Case Officer: Katherine Daniels

Applicant: Great Lakes UK Limited

Proposal: 1. Introduction of ventilation grilles above all guestroom windows;
2. Reduction of brick plinth to back of house areas of waterpark building;
3. Change of rear of hotel from stone to render retaining stone surrounds and sills; 4. Change of rear of hotel from stone to timber with timber surrounds and metal sills; 5. Change from stone plinth to buff brick plinth to back of house areas of waterpark building; 6. Change of buff brick from blue brick material around plinths; 7. Reduction of extent of plant screening above conference zone where plant is no longer present; 8. Reposition slow windows to eaves to raise them slightly; and, 9. Re-align windows above porte cochere (proposed as non-material amendment to 21/04158/F)

10875-EPR-00-RF-DR-A-TP-0349

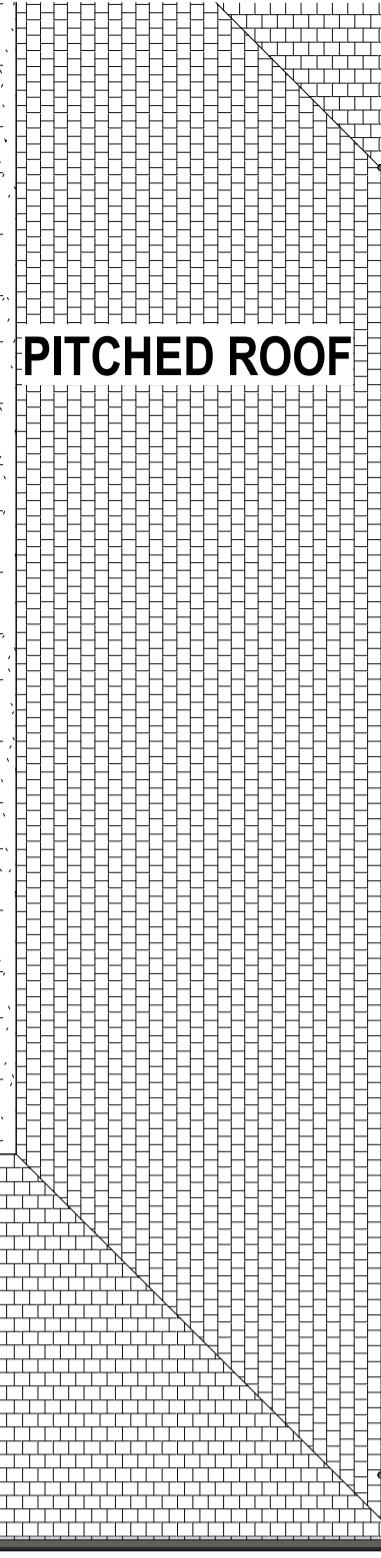
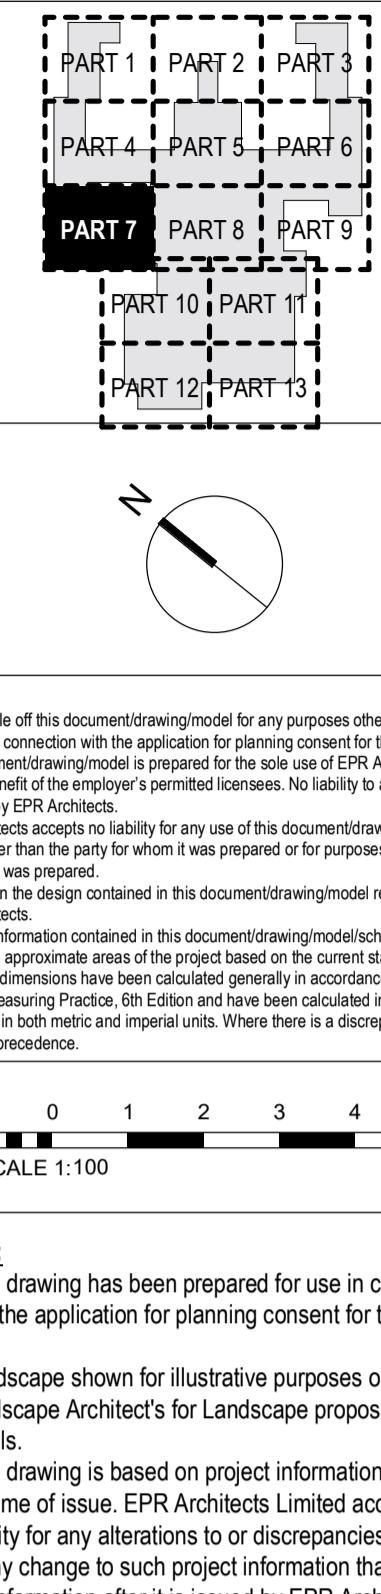
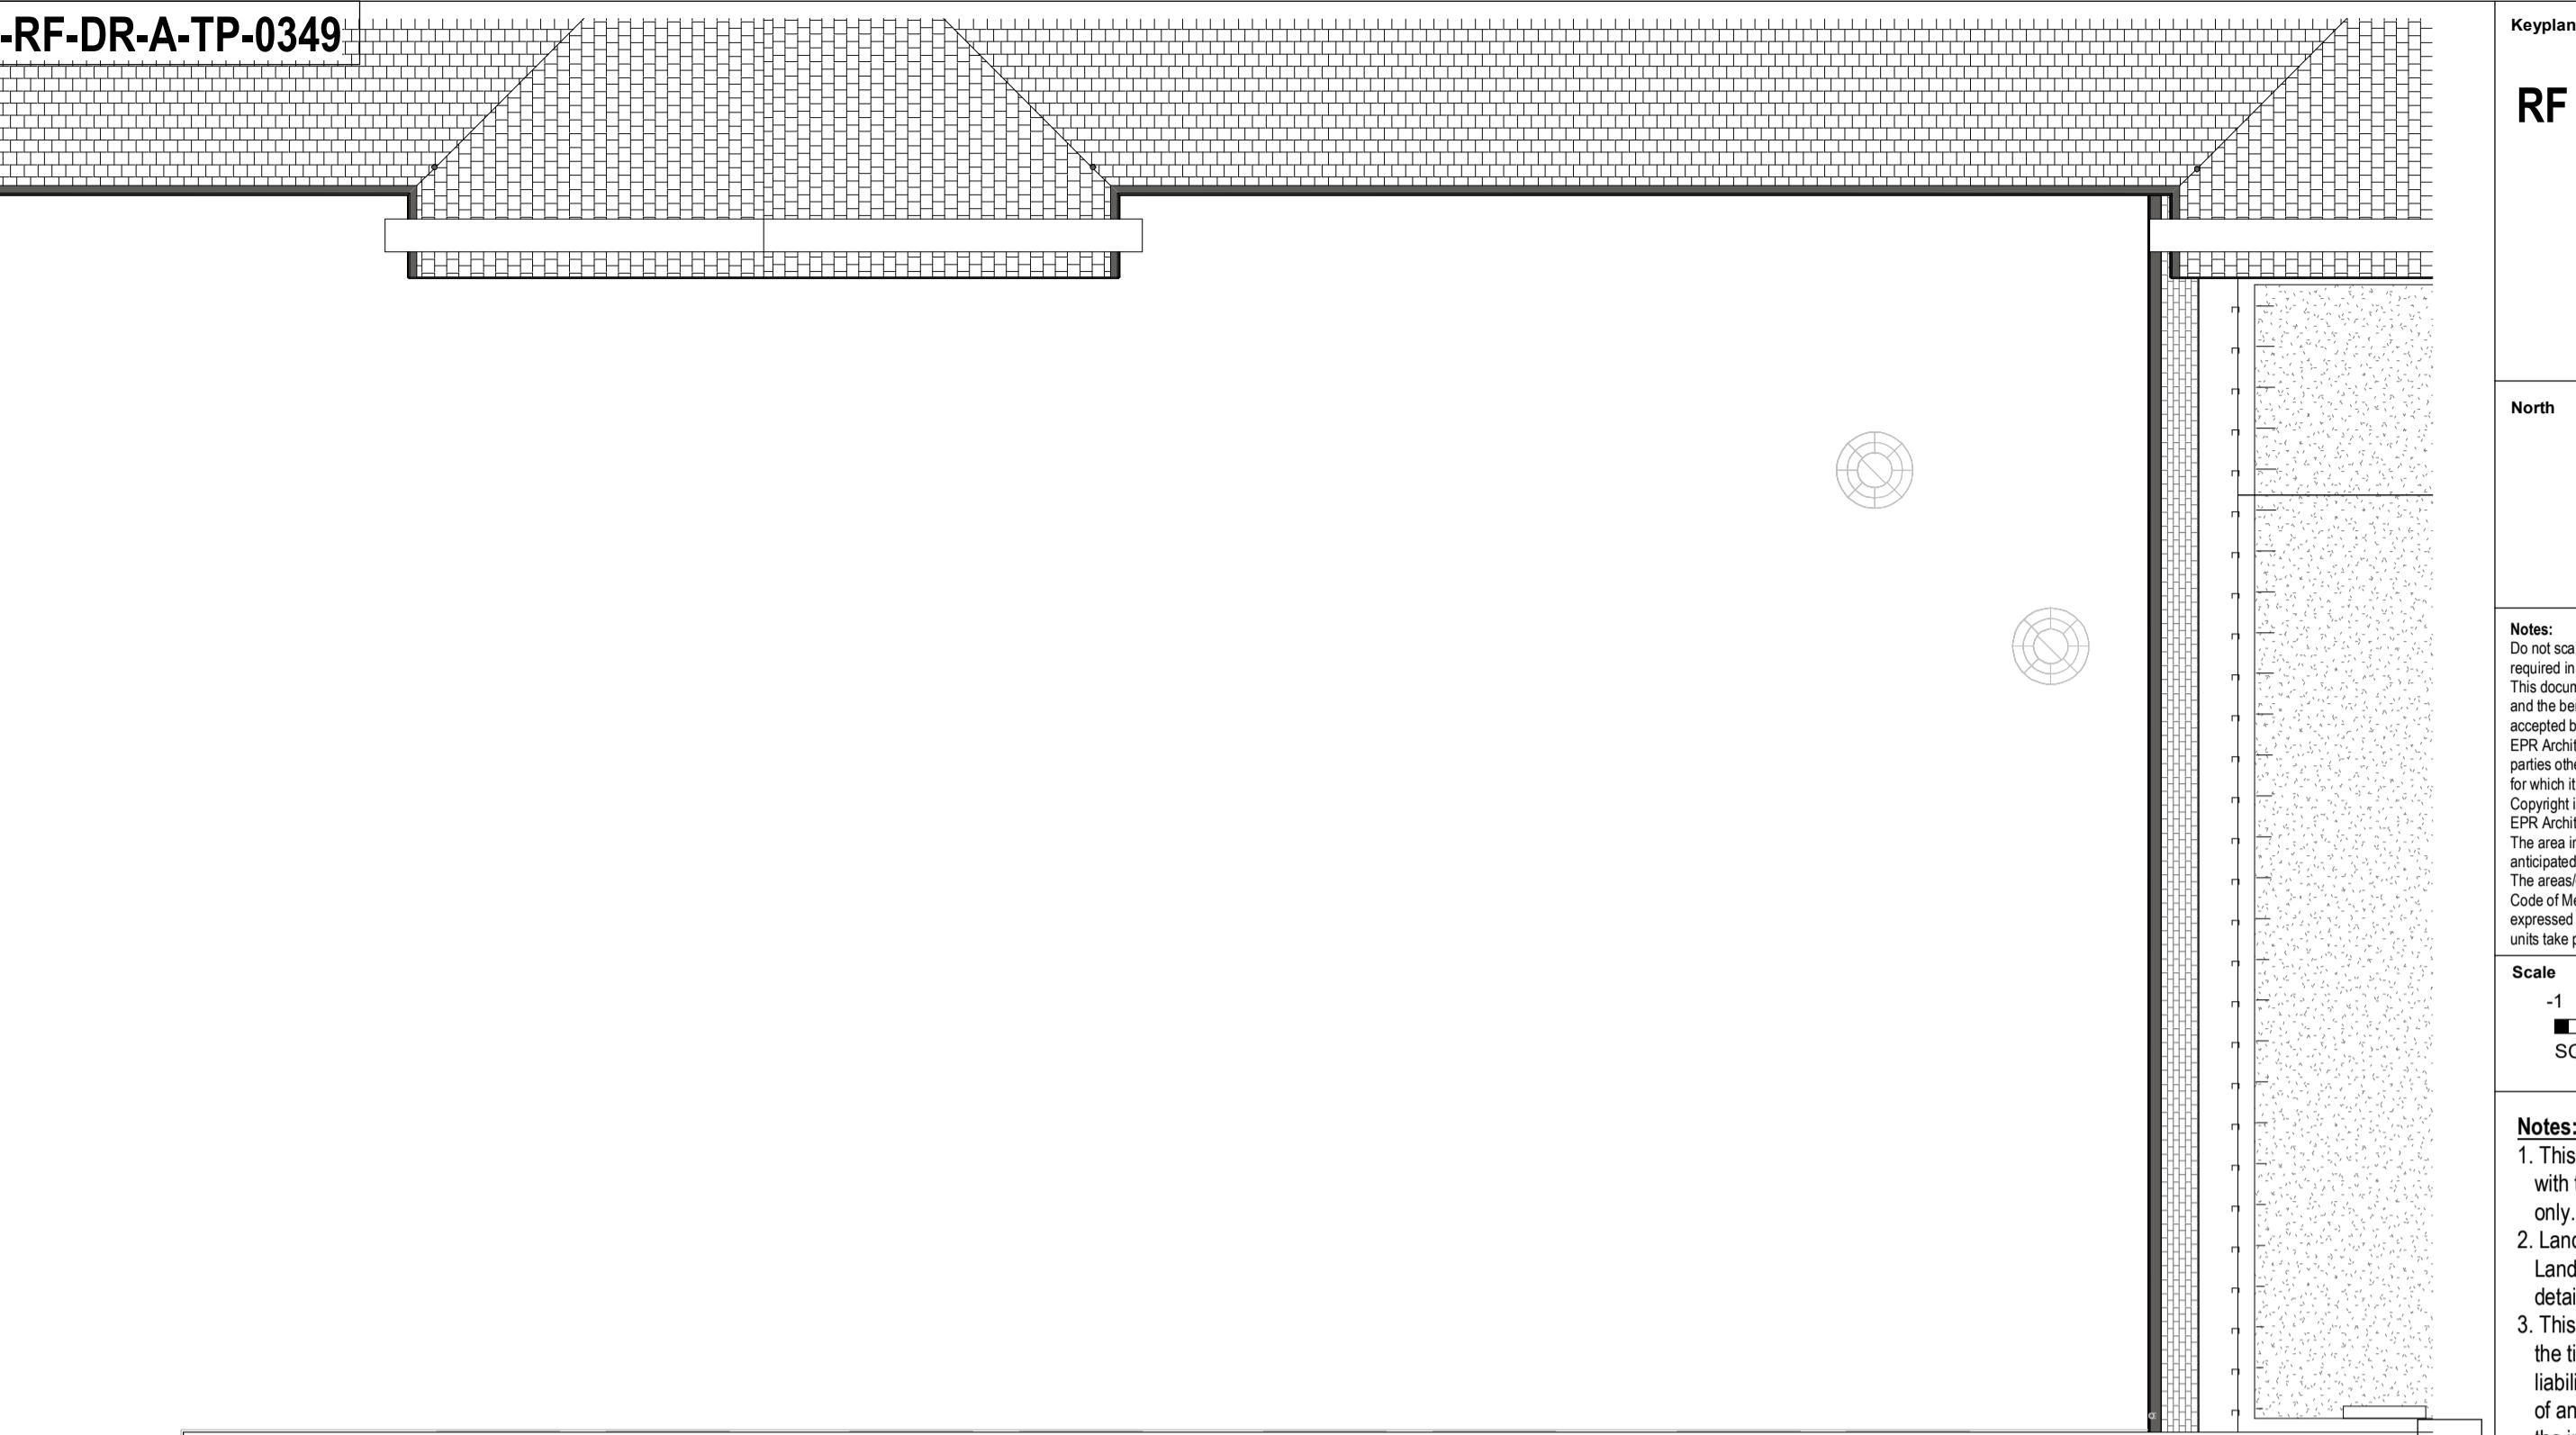
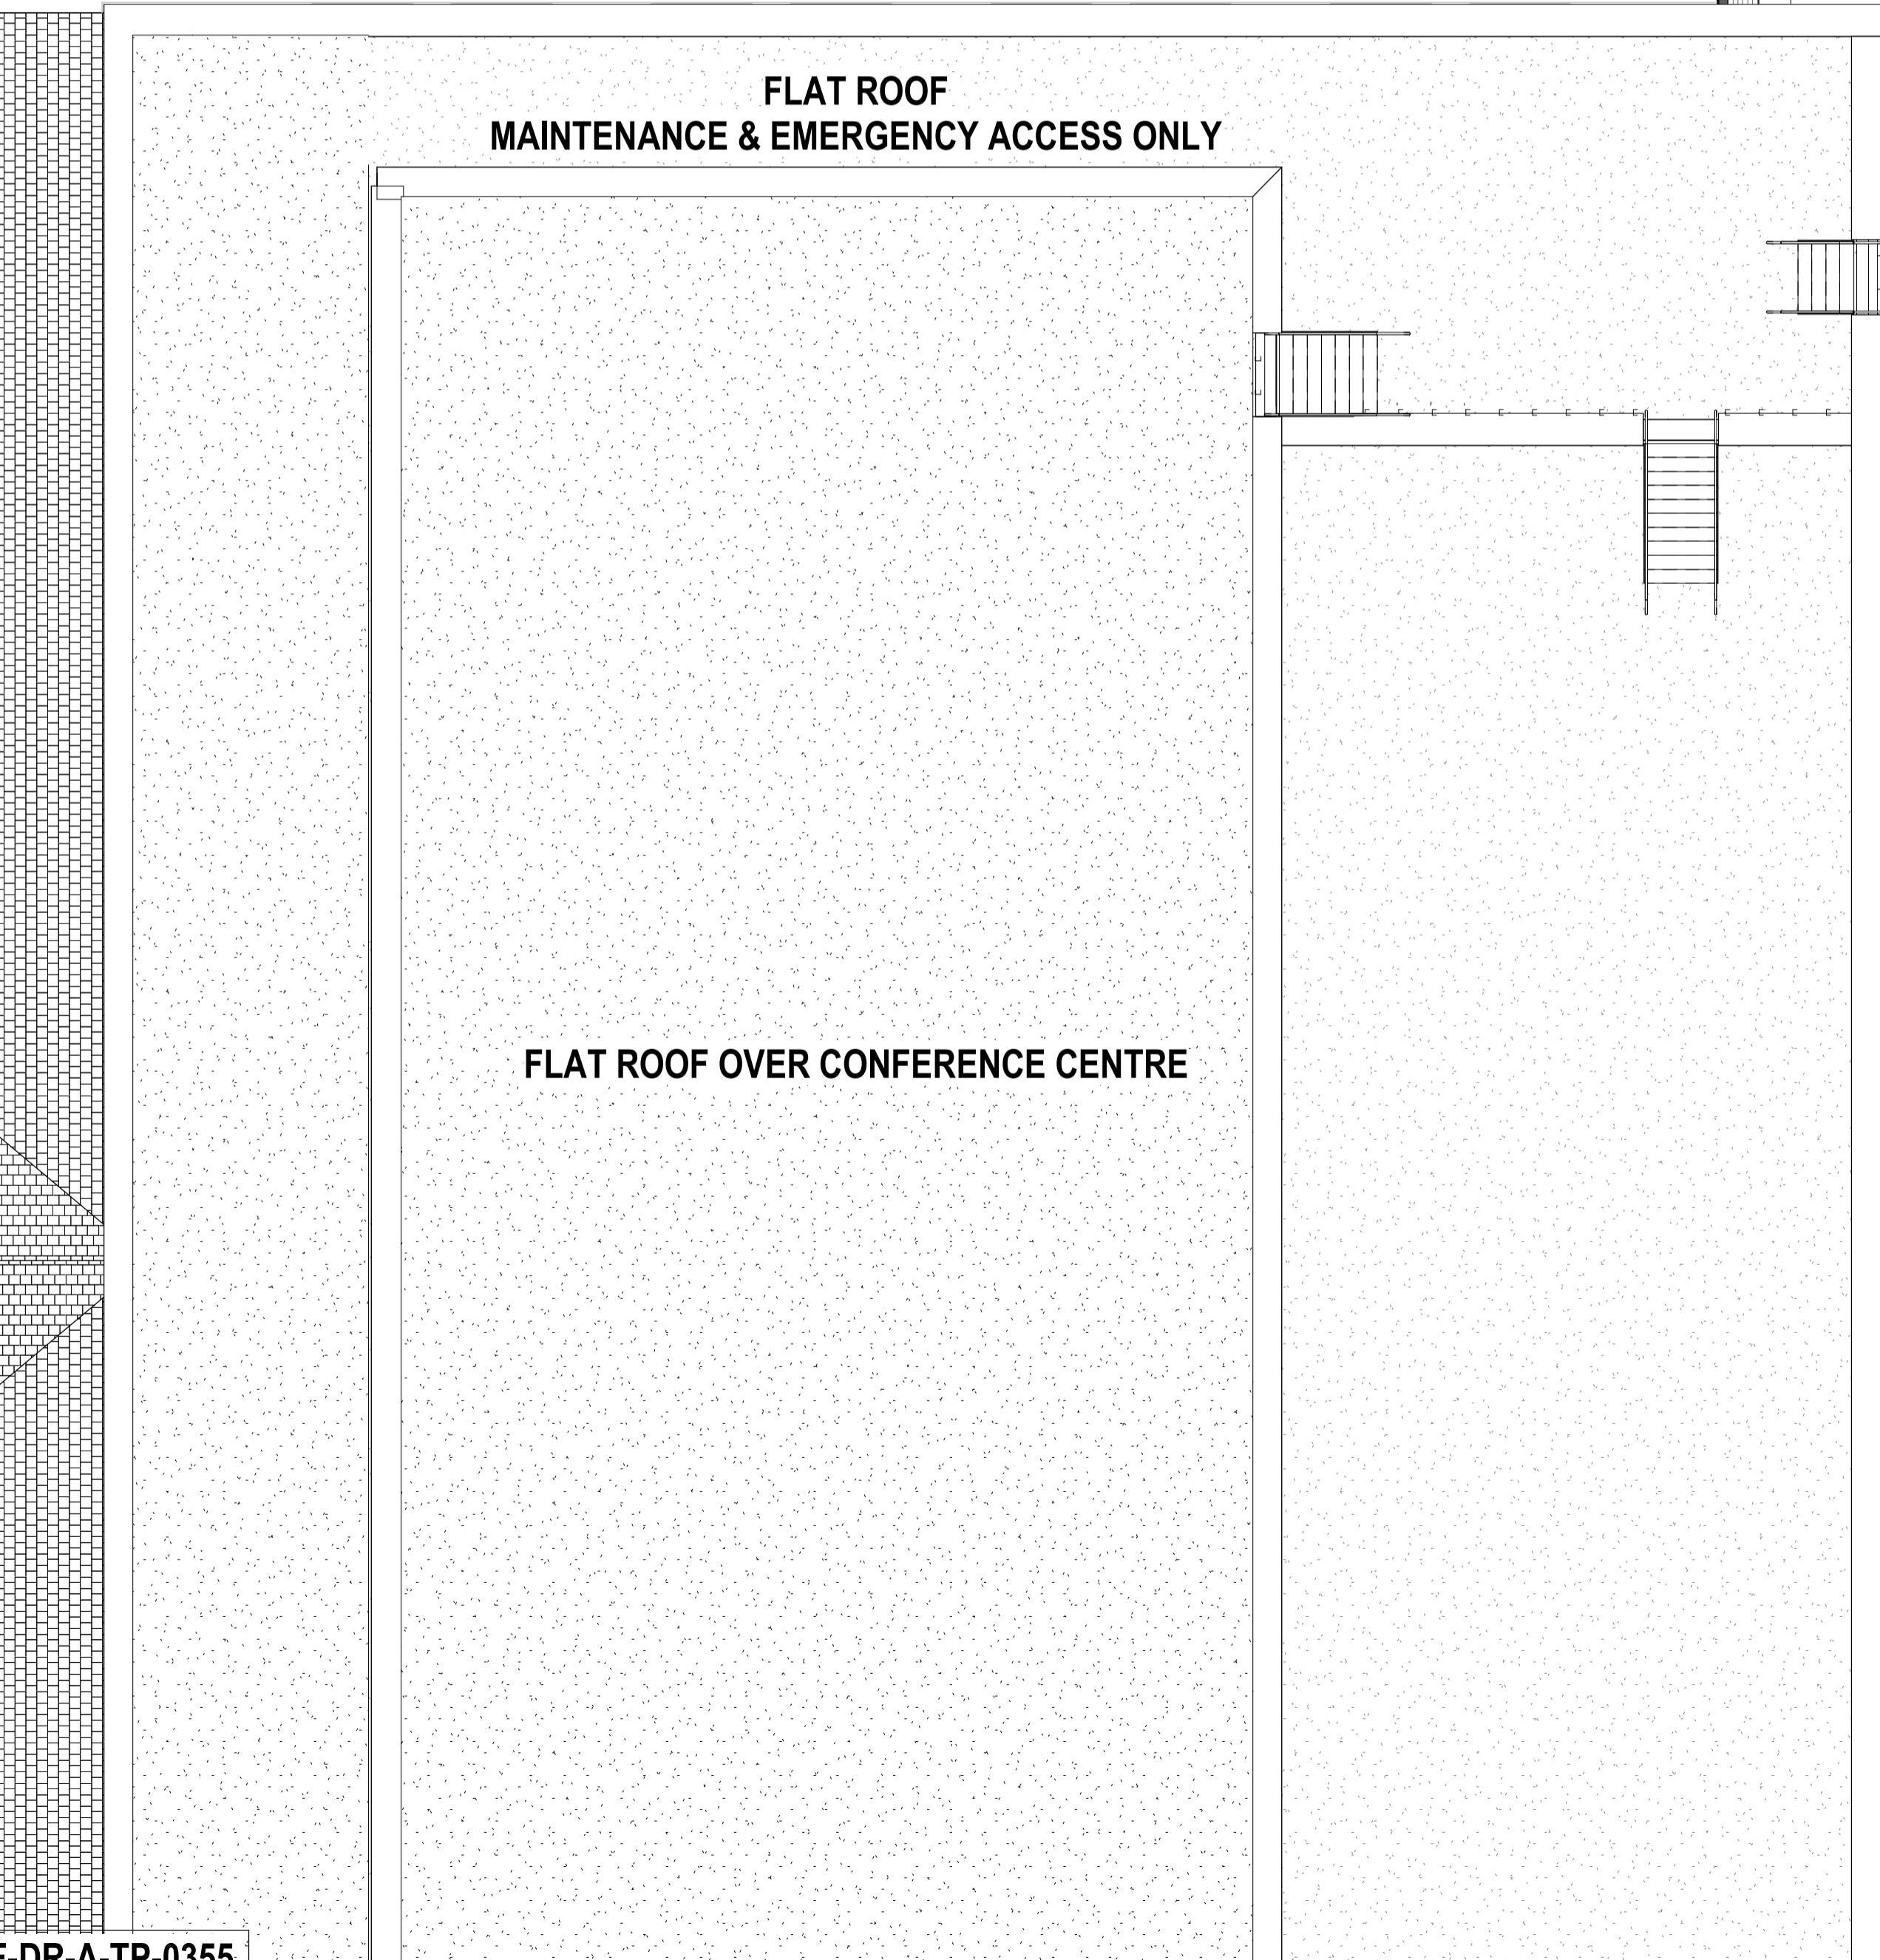
- 5.10. The reduction of plant screening, is considered to be acceptable, and will not alter the overall development as a whole.
- 5.11. The reposition of the slow windows to eaves and raise them slightly again does not alter the overall design and appearance of the original scheme. The changes to these are minimal.
- 5.12. The windows are due to be re-aligned above the porte cochere changes are considered to be acceptable and does not affect the overall character and appearance of the building.
- 5.13. It is considered that some of the changes are unfortunate, however, overall, it is considered that the proposed alterations, given the overall size of the development will not alter the character and appearance of the proposed development. The alterations are considered to be non-material.
